DPIE reference: SSD 9383

### **SSD 9383: Site 2A/2B DRP – Public Domain Response**

I refer to the revised public domain and landscape response relating to Sites 2A and 2B which was received by Sydney Olympic Park Authority (SOPA) on 6 August 2019 and subsequently presented by the architectural and landscape team on 7 August 2019 to SOPA officers and the independent Chair for the Design Review Panel (DRP).

VIEW 01: SITE 2A FORECOURT

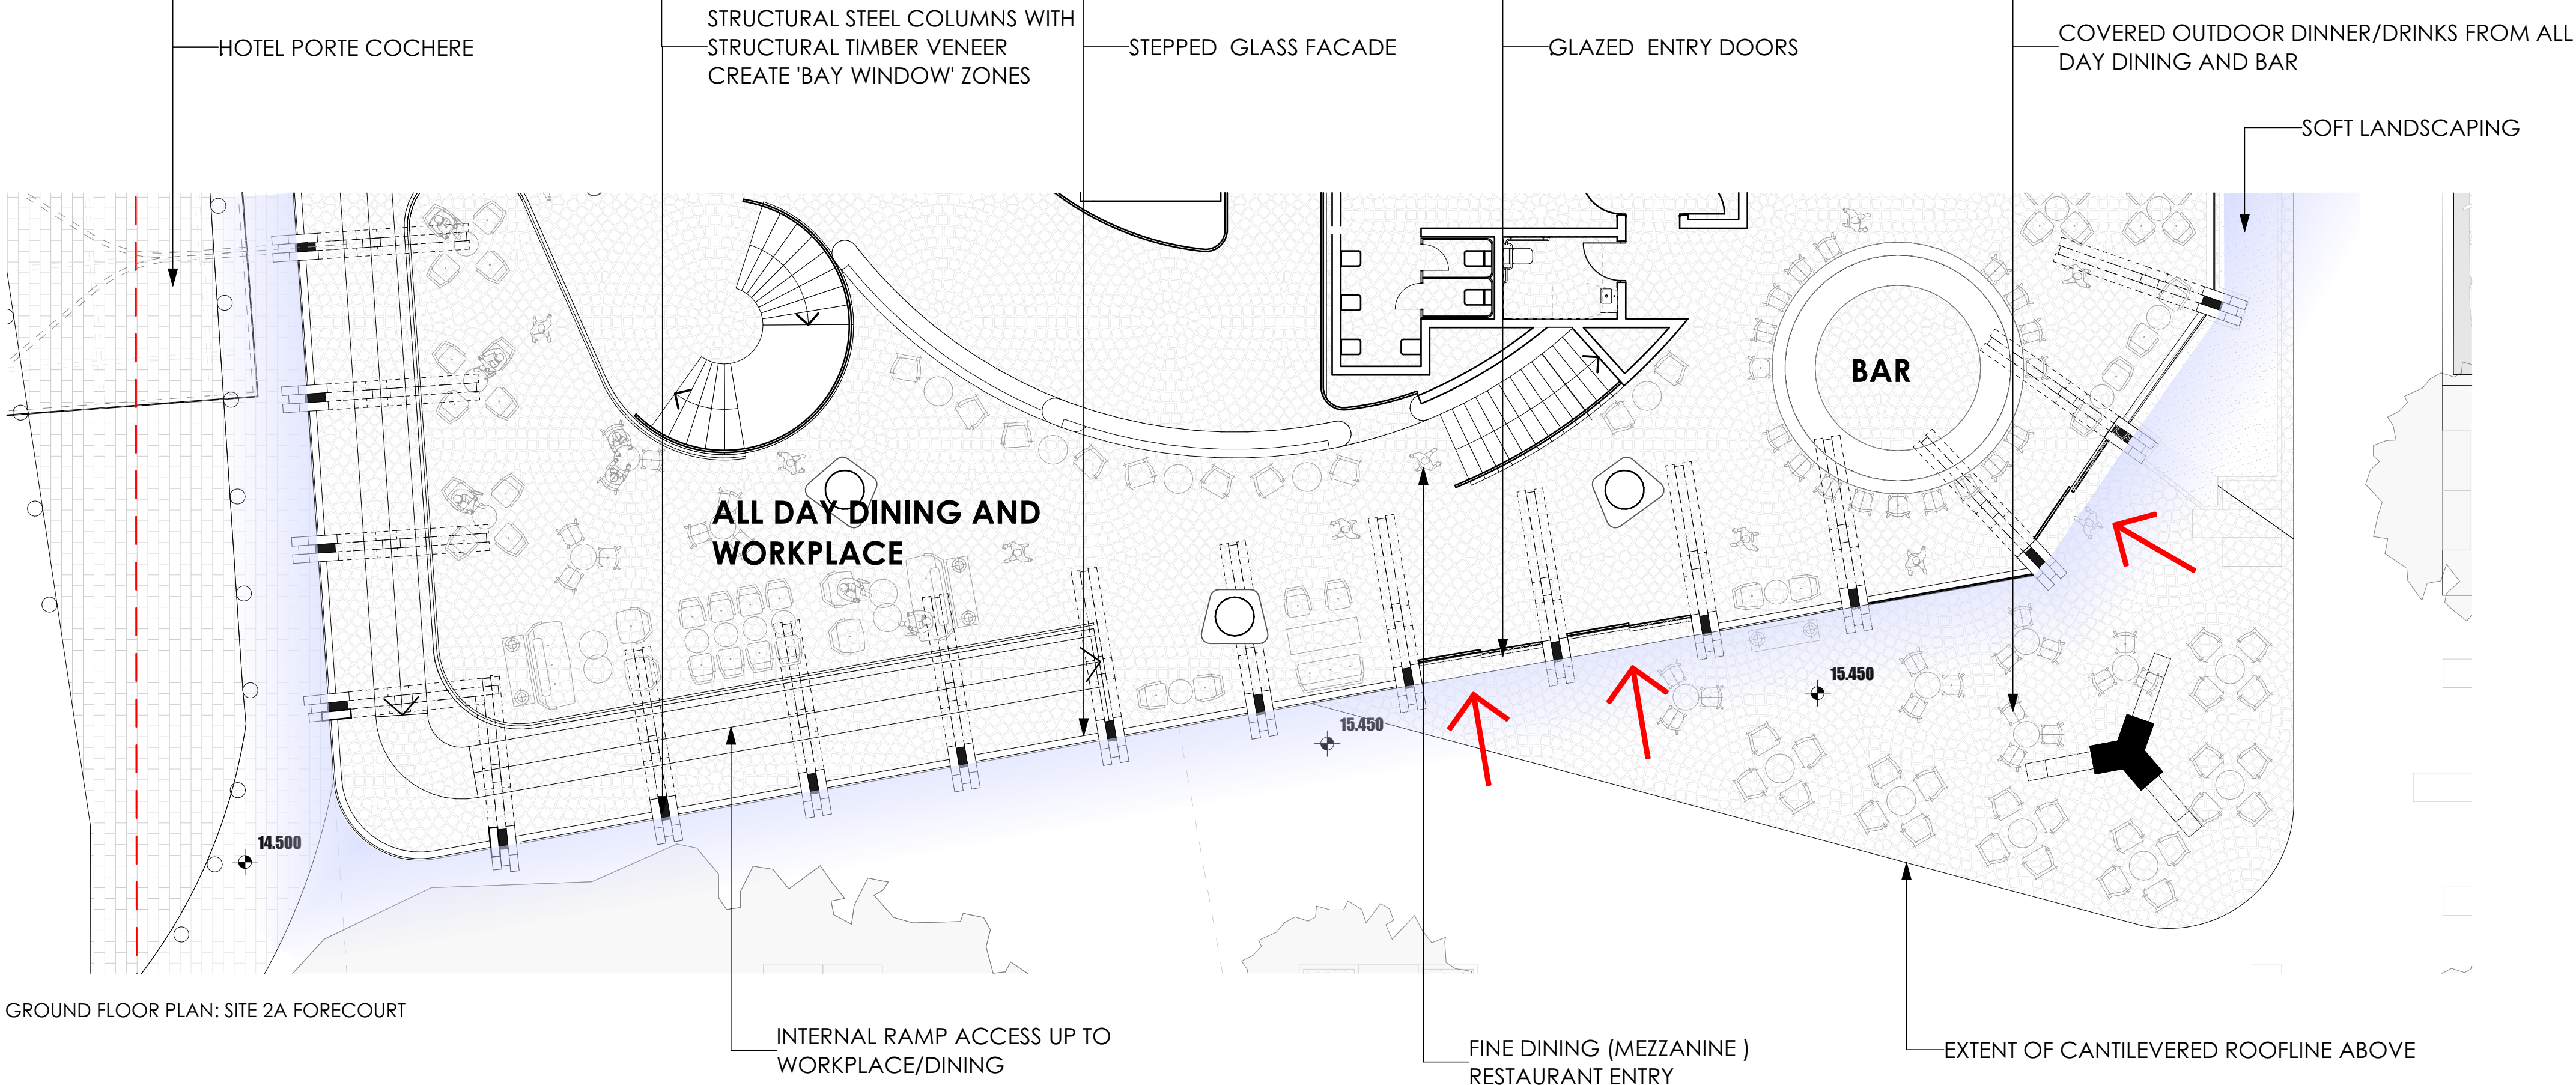
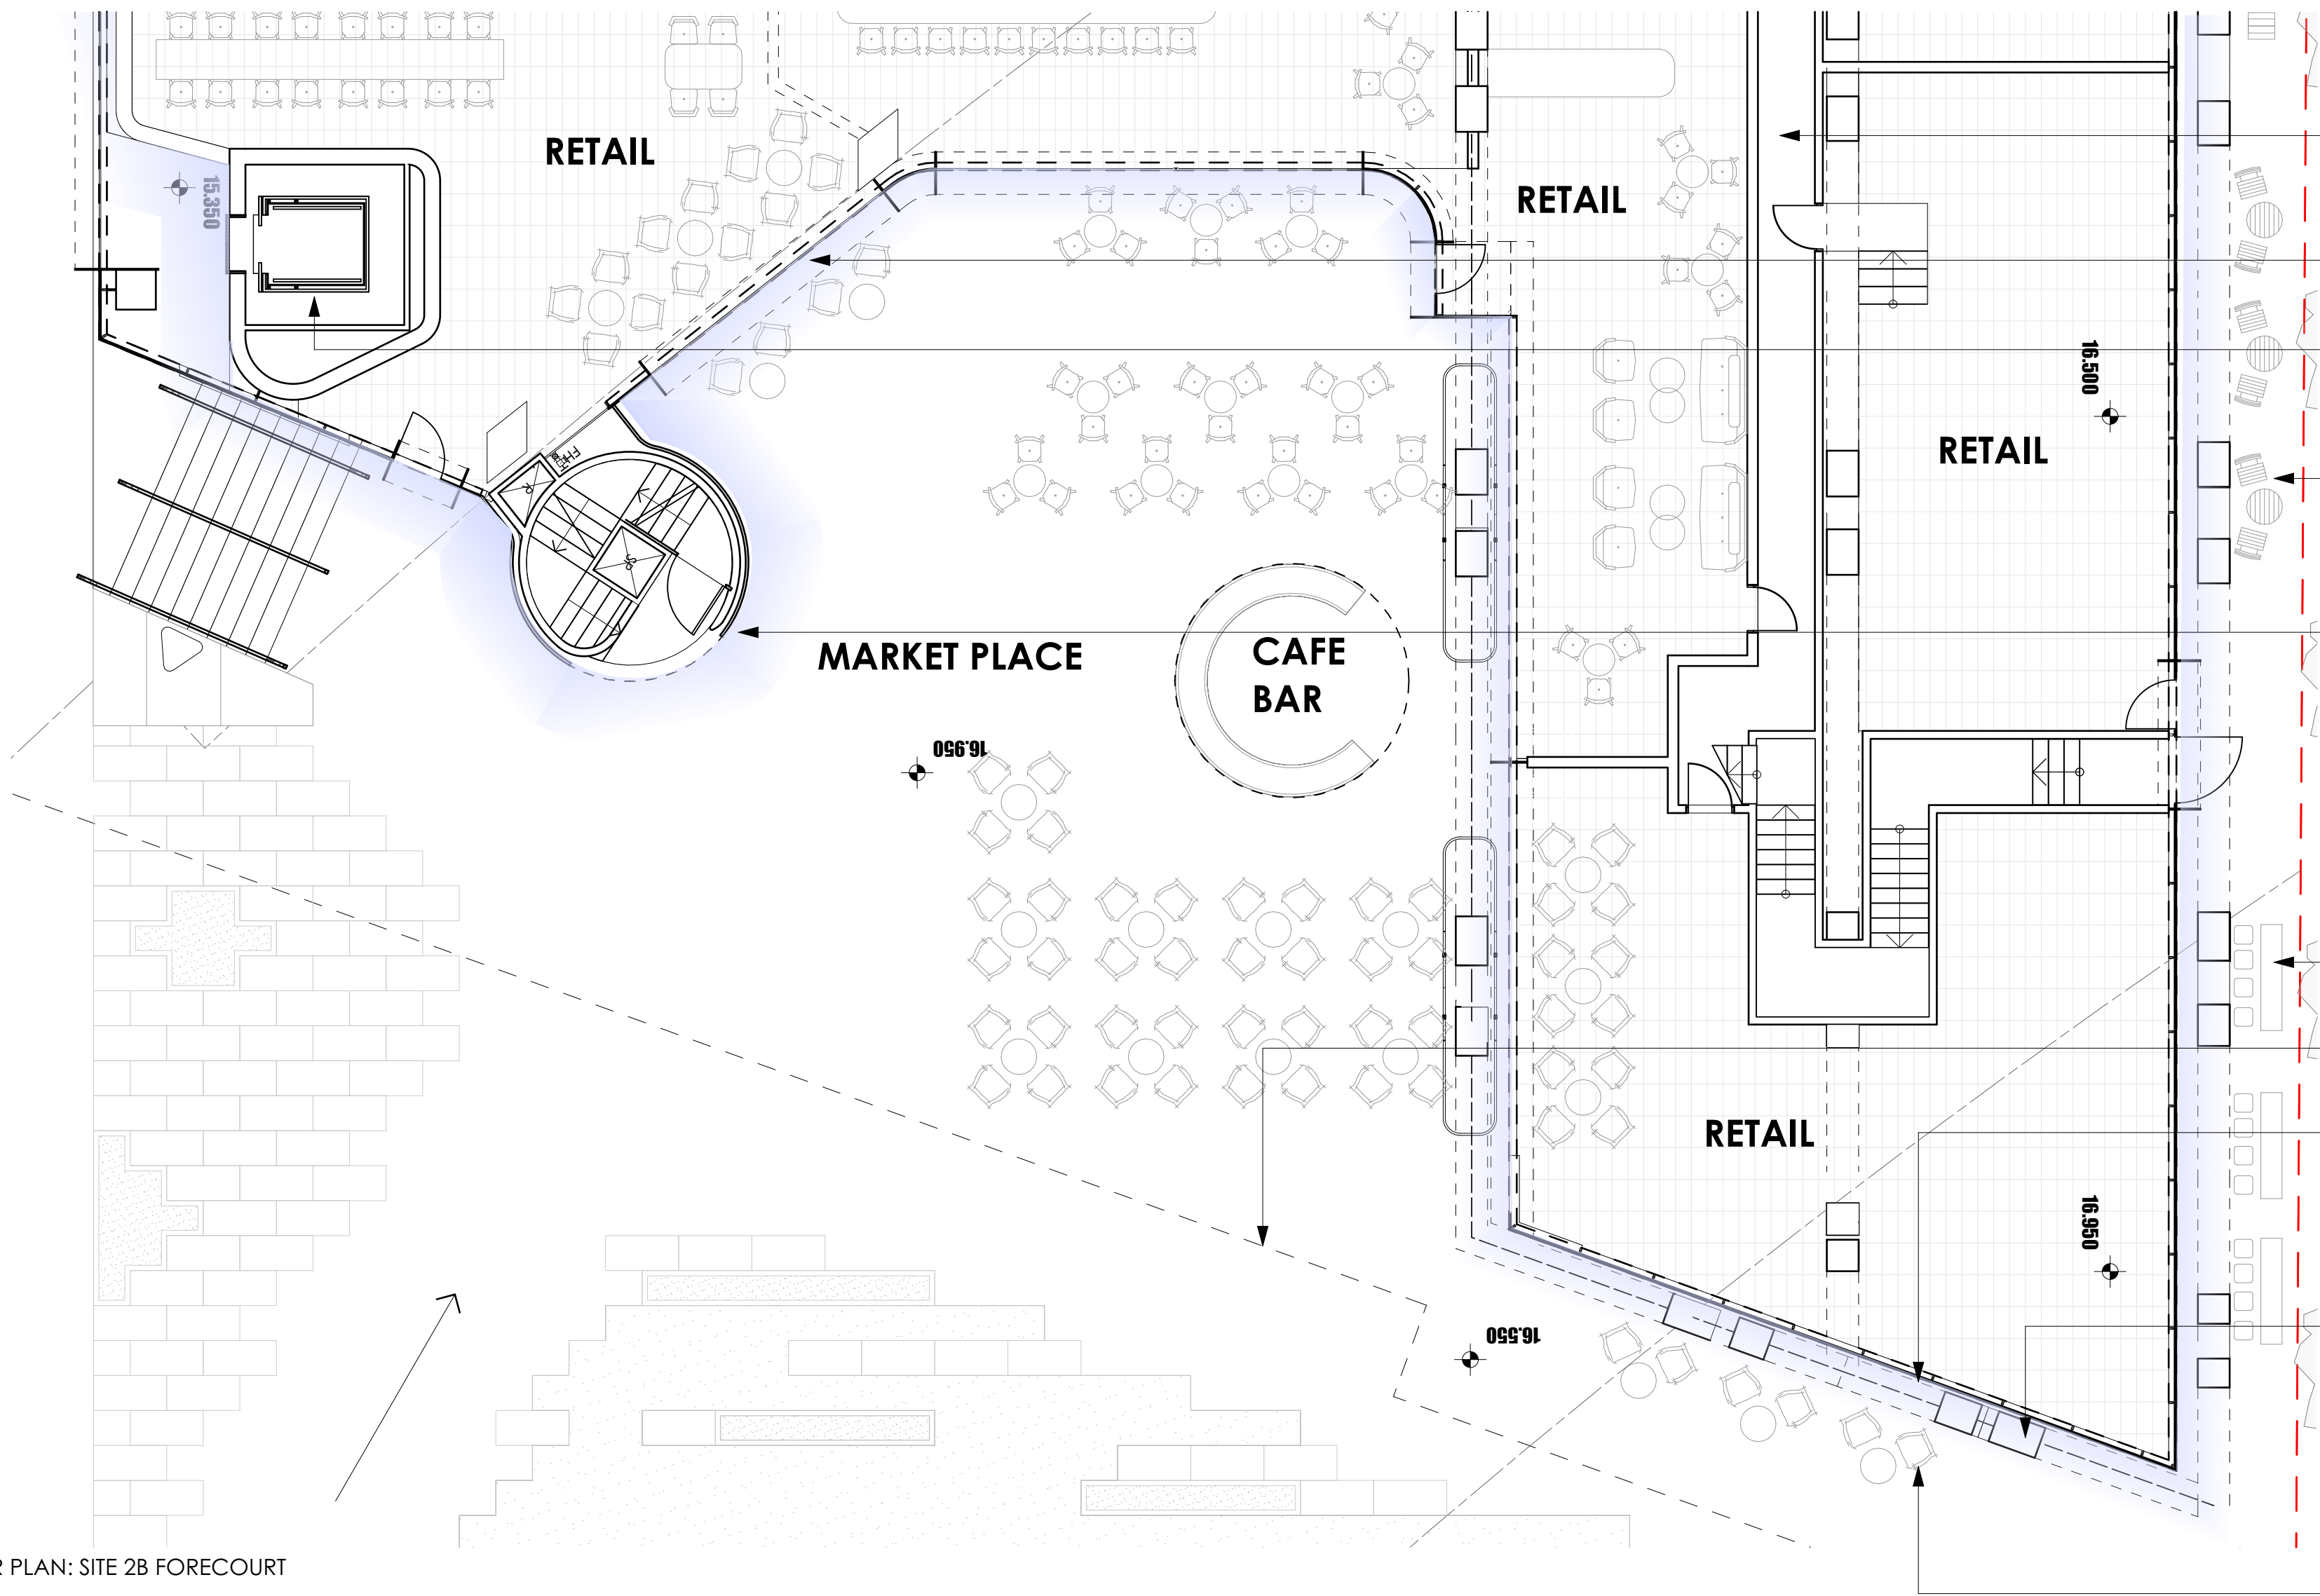
The revised approach to the retention of the fig tree is considered an improvement to the netting idea. However, the angularity of the stepped terrace, and significant use of brick blocks down to the tree appears to jar with the naturally curving nature of the fig tree.

Furthermore, the observation deck shows what appears to be a canter-levered area, which may have the potential to create dark and uninviting spaces beneath it and around the base of the fig tree. Further consideration with regard to how this space will be treated to ensure its safe, welcoming and inviting is required.

The current design indicates no difference between the internal public domain paving and the pedestrian paved areas along the streets. Consideration should be given to creating a hierarchy for pedestrian flows and better defining, through materials and scale, the edges to the internal spaces.

Specifically, it is noted that the widths of pedestrian routes within the site are set at 2.4m which is the standard width for pavements within Sydney Olympic Park. These widths however are not required for internal pedestrian routes within the landscaping spaces. The inclusion of less formal routes could be pursued and potentially assist in creating a hierarchy through the space.
